ISSUE 01 - VISUAL IMPACT TO HARBOUR VIEWS FROM ASTOR APARTMENT BUILDING

ISSUE 02 - PRIVACY FOR ASTOR APARTMENT BUILDING

Key view corridors & vistas
from impacted public domain &
residential buildings

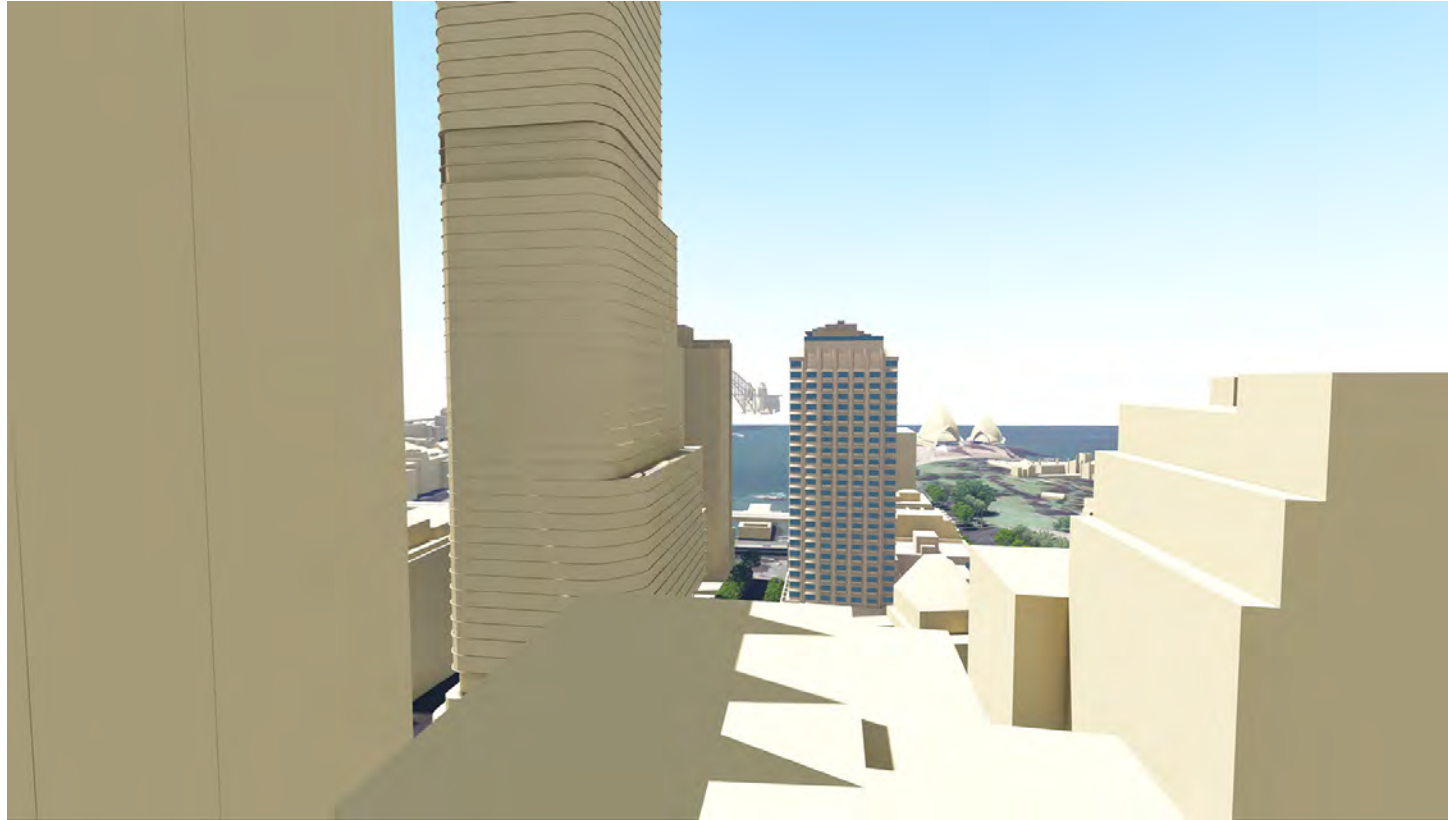
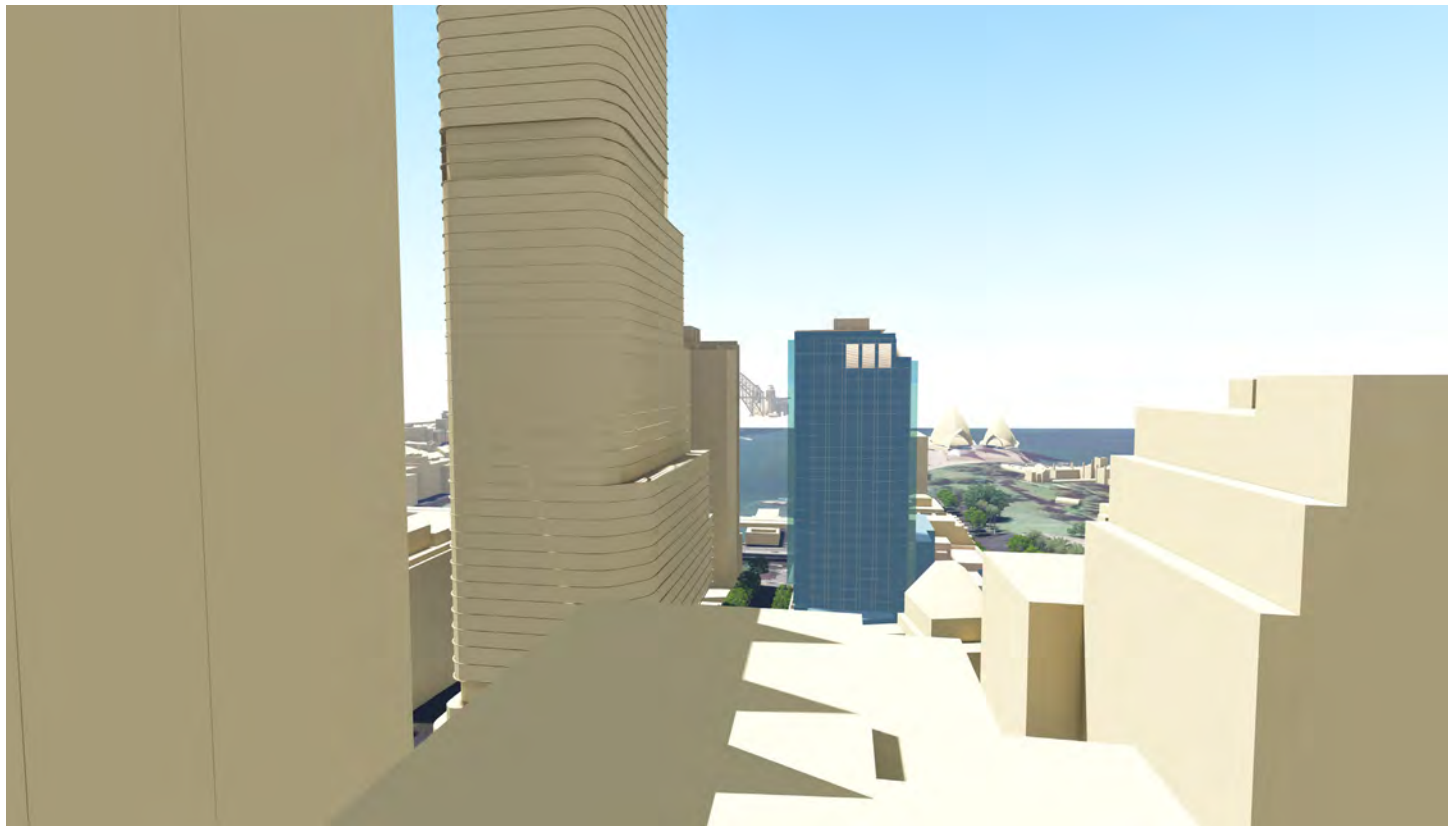
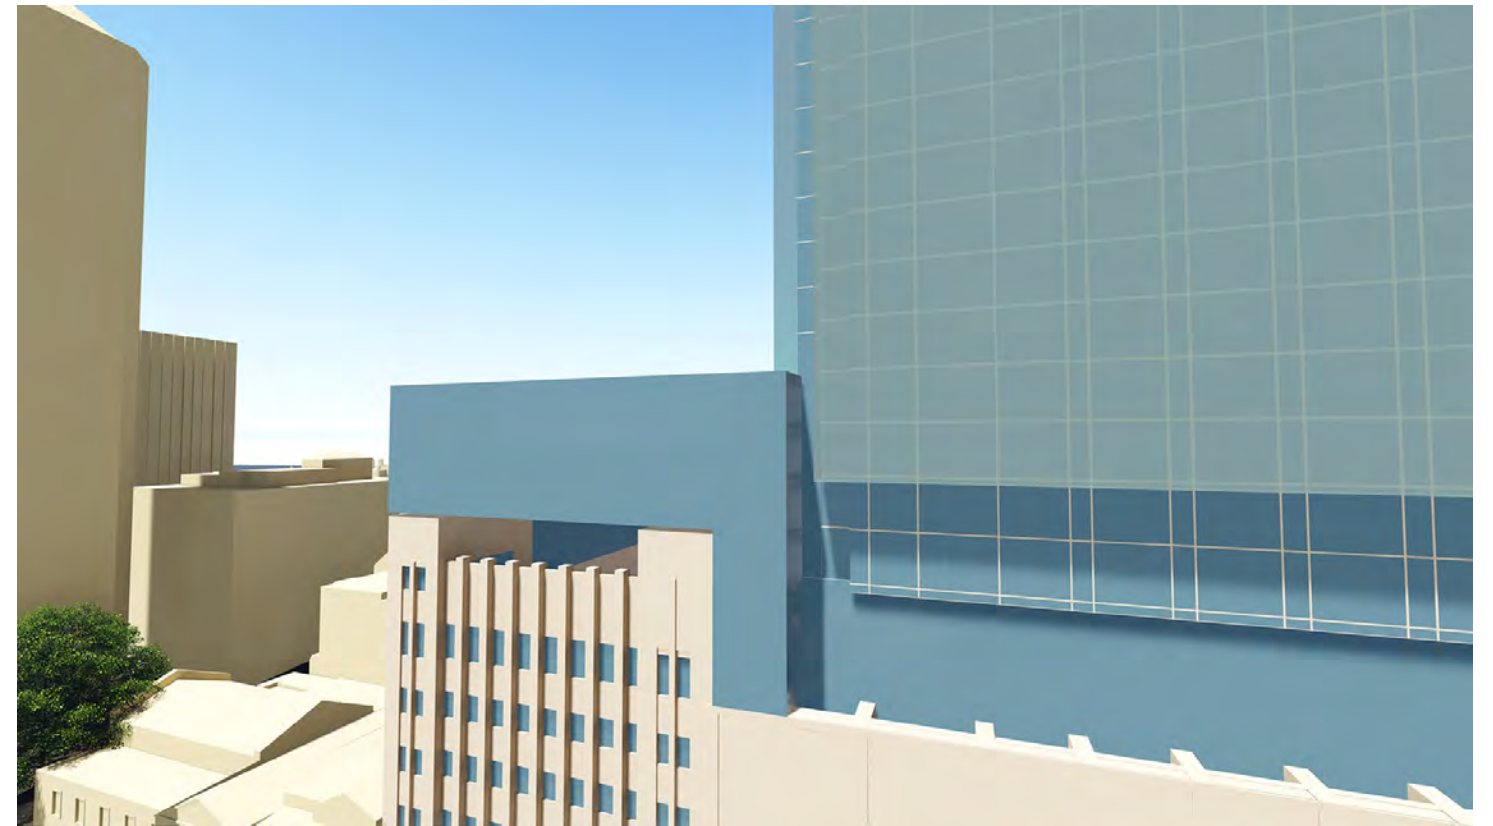
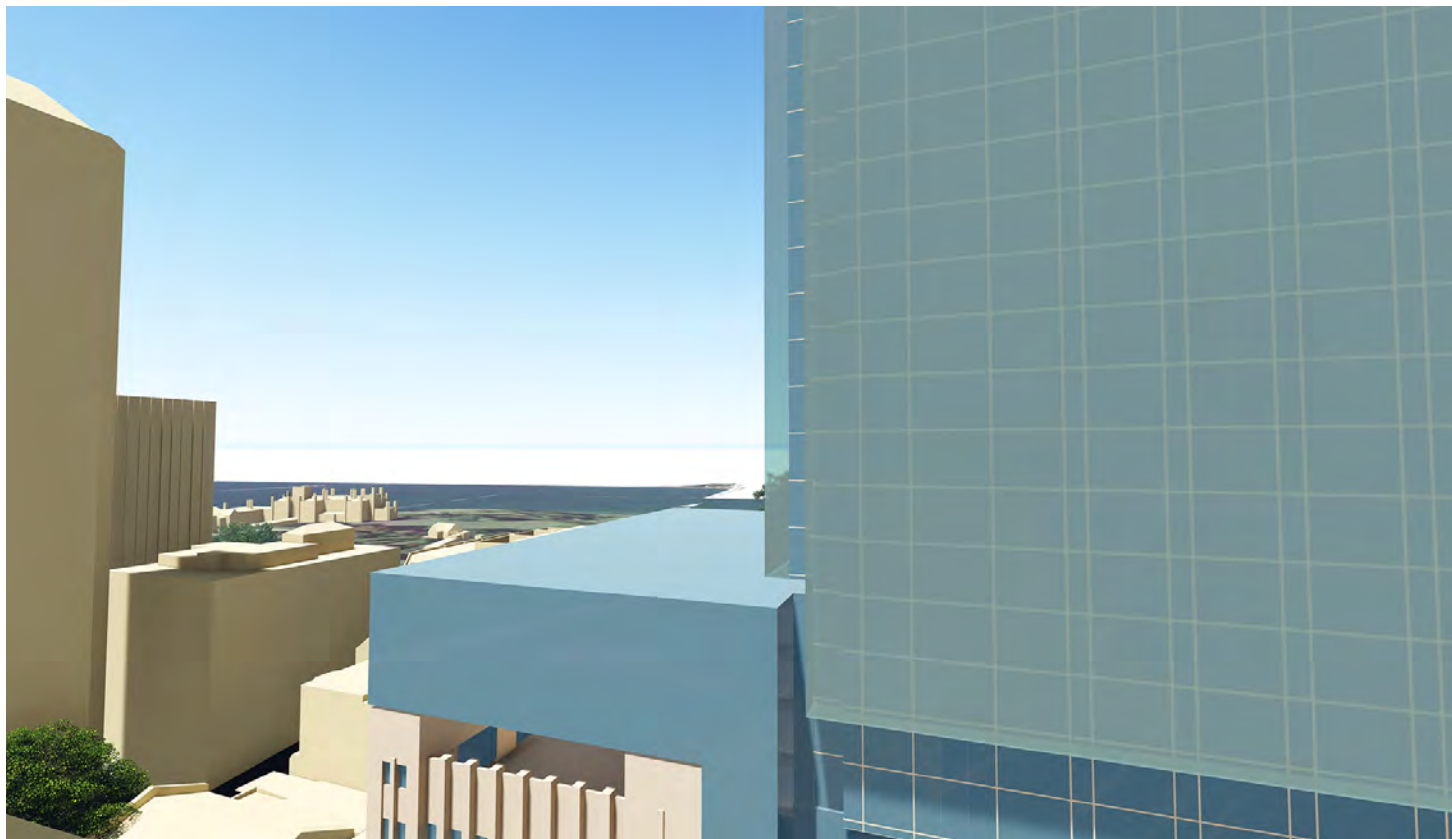
Summary:
The Visual Impact on the Astor Apartment Building, undertaken by Hassell (Attachment 3), has been assessed from an eastern location on the rooftop and also from one of the upper floor apartments. (Indicated as Level 10 but actually Level 11)

This is not a complete reflection of the potential impact on all apartments with views of the harbour. The impact of the proposed development increases significantly in magnitude for the lower floor windows and those to the west, on the northern elevation.

It is requested that the full extent of the visual impact affecting the apartments on the north facing side of the Astor building, from level 11 to level 6, be established.
